Re: SSD 9522 - Response to Submissions, Kemps Creek Warehouse and Logistics Hub – Mamre South Precinct (SSD 9522), Kemps Creek, NSW.

This letter addresses the submission from EES Group in relation to SSD 9522. Submissions were provided in an email from Travis Lythall (Senior Town Planner, Willow Tree Planning), dated 2 September 2020. The submissions and Ecoplanning’s responses to these submissions are provided in **Table 1**.

Table 1: Ecoplanning response to EES Submissions.

Figure 4.3: Survey effort.

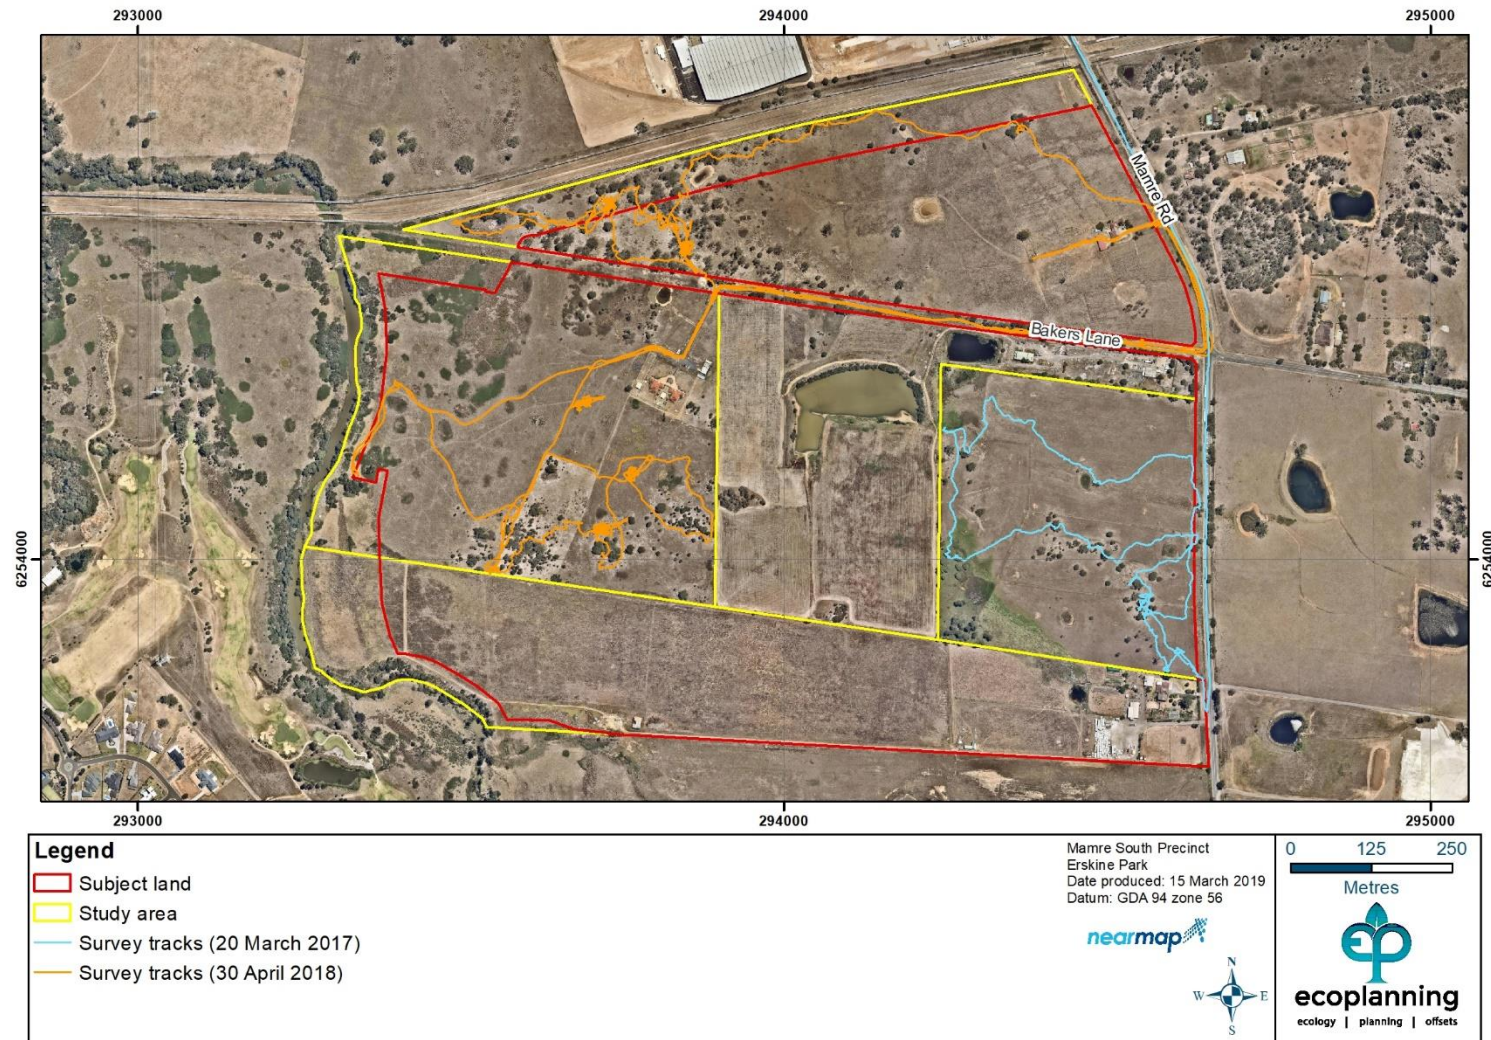
<p>2016. That report has been replaced by guidelines issued in April 2020 after most of the surveys for this proposal were conducted, so EES is unable to determine if they were in accordance with that document. The apparent 50m+ distance between survey traverses shown in Fig. 4.1 would make it difficult to detect the less visible species. As most of the site is exotic pasture, this is only problematic in the mapped native vegetation within the subject land. It is noted, however, that there is a low likelihood of the presence of any of the identified candidate flora species.</p>	<p>The vegetation within the study area is not considered suitable habitat under Section 3.3 of the 2020 guidelines. Consequently, the methodology and intensity of the survey is considered adequate.</p>
<p>The only critical matter is the identification of PCTs as misidentification of PCT 849 as PCT 835 will result in both lower credit requirements and lower credit prices. The tabulated data in Appendix C of the BDAR is difficult to review as it is not in excel format, as required by the BAM.</p>	<p>The tabulated data presented in Appendix C of the BDAR has been provided with the email that this letter has been attached to. It has also been uploaded to BOAMs.</p>
